**EL PASO COUNTY PLANNING AND
 COMMUNITY DEVELOPMENT
 DEPARTMENT**

STORMWATER MANAGEMENT PLAN CHECKLIST

Revised: July 2019

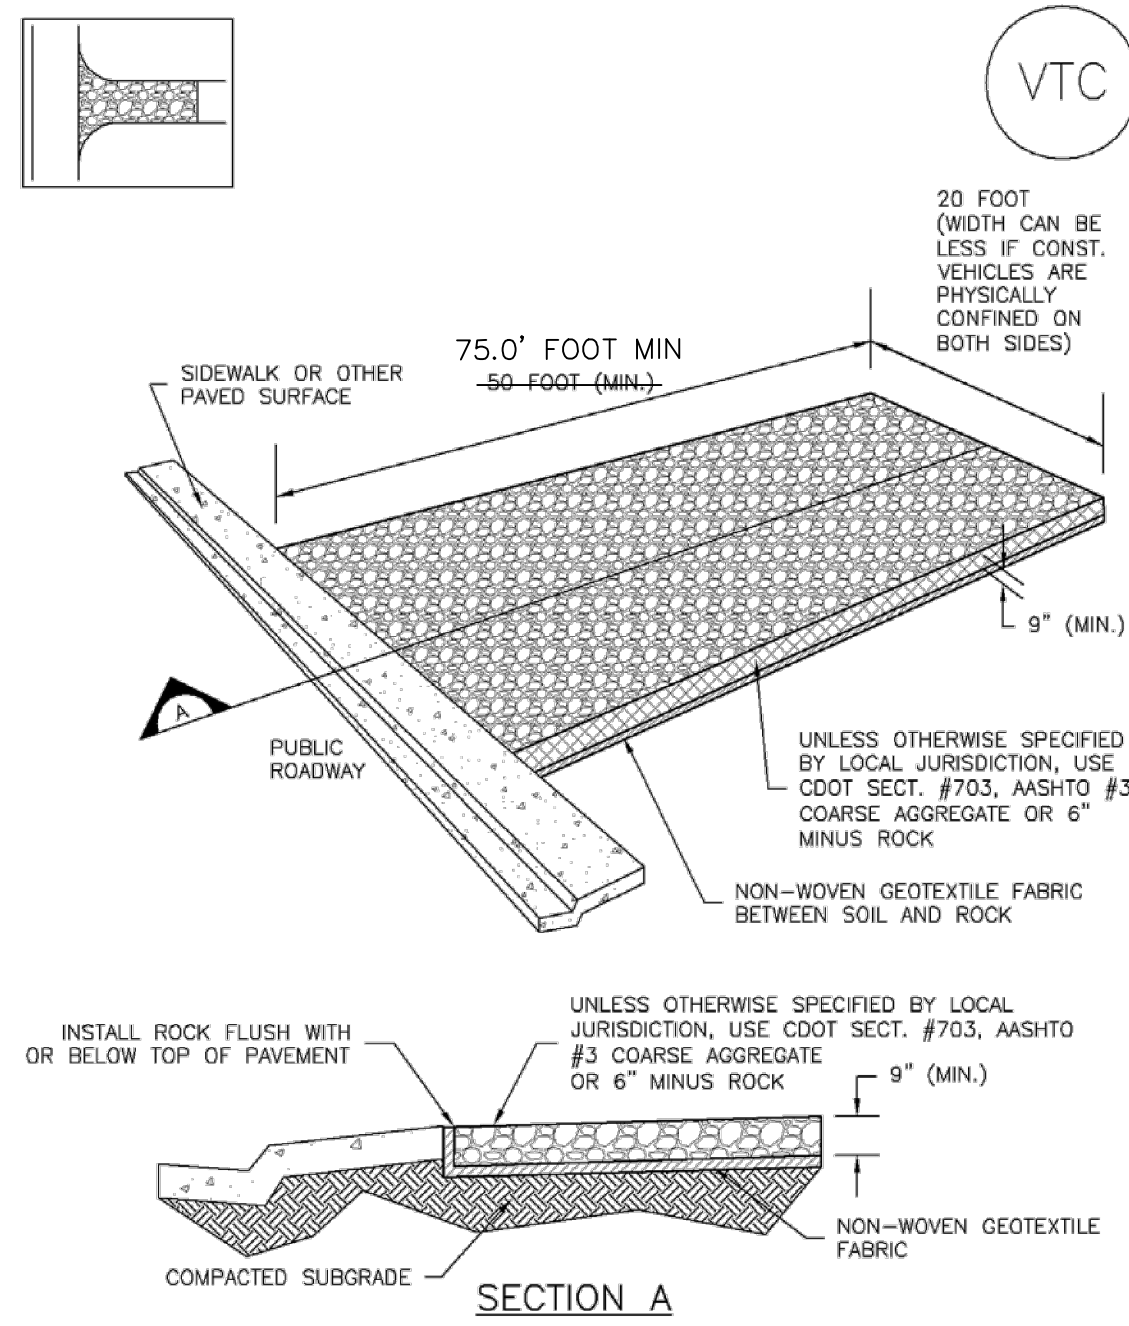
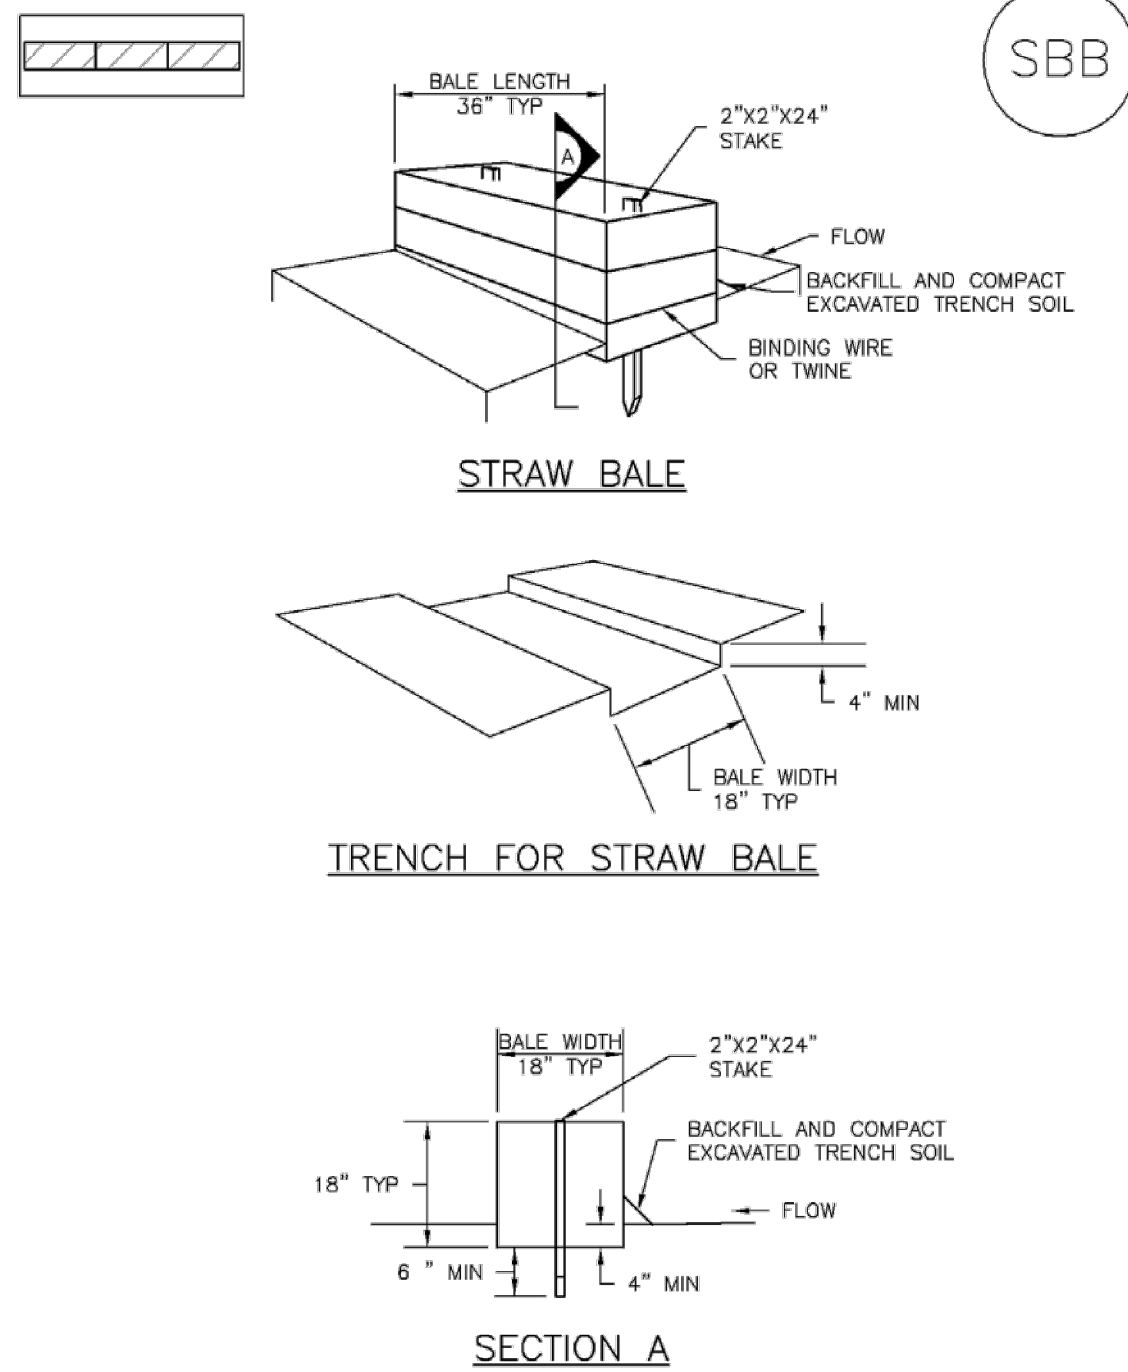
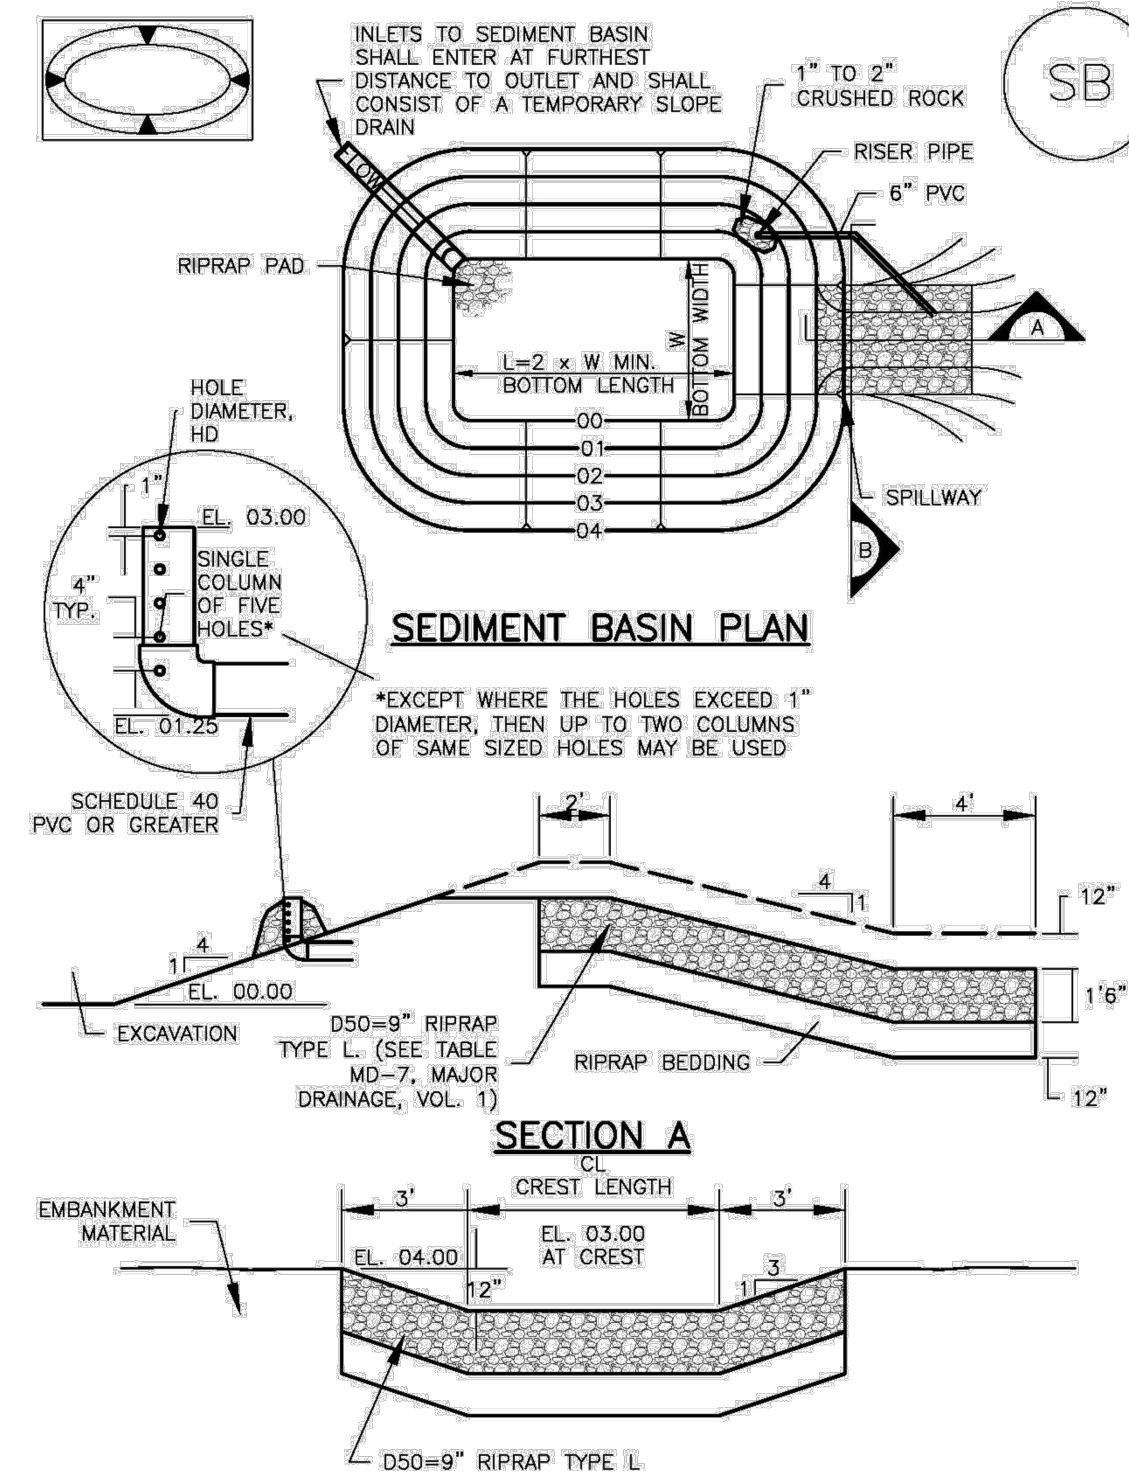
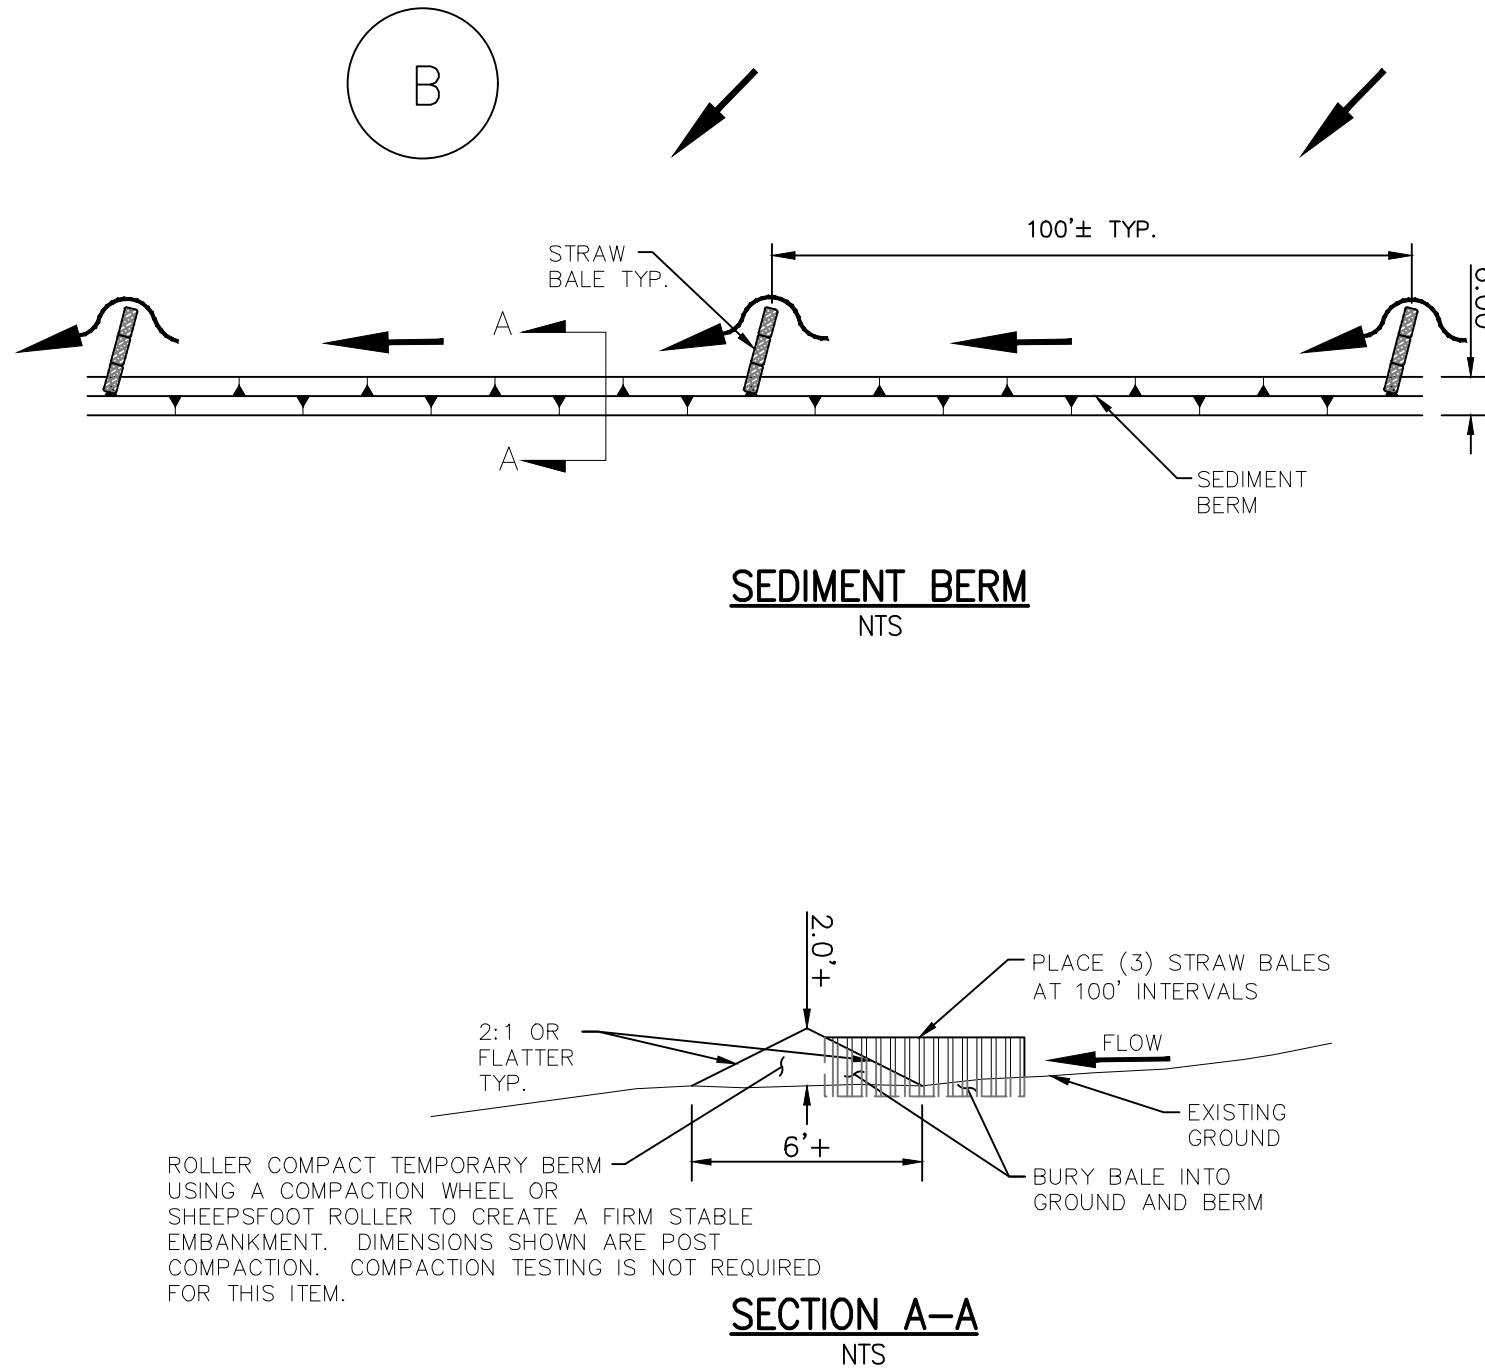
20	Technical drawing details for all control measure installation and maintenance, custom or other jurisdiction's details used must meet or exceed EPC standards	✓	X
21	Procedure describing how the SWMP is to be revised	✓	✓
22	Description of Final Stabilization and Long-term Stormwater Quality (describe nonstructural and structural measures to control SW pollutants after construction operations have been completed, including detention, water quality control measure etc.)	✓	✓
23	Specification that final vegetative cover density is to be 70% of pre-disturbed levels	✓	✓
24	Outline of permit holder inspection procedures to install, maintain, and effectively operate control measures to manage erosion and sediment	✓	✓
25	Record keeping procedures identified to include signature on inspection logs and location of SWMP records on-site	✓	✓
26	If this project relies on control measures owned or operated by another entity, a documented agreement must be included in the SWMP that identifies location, installation and design specifications, and maintenance requirements and responsibility of the control measure(s).	✓	✓
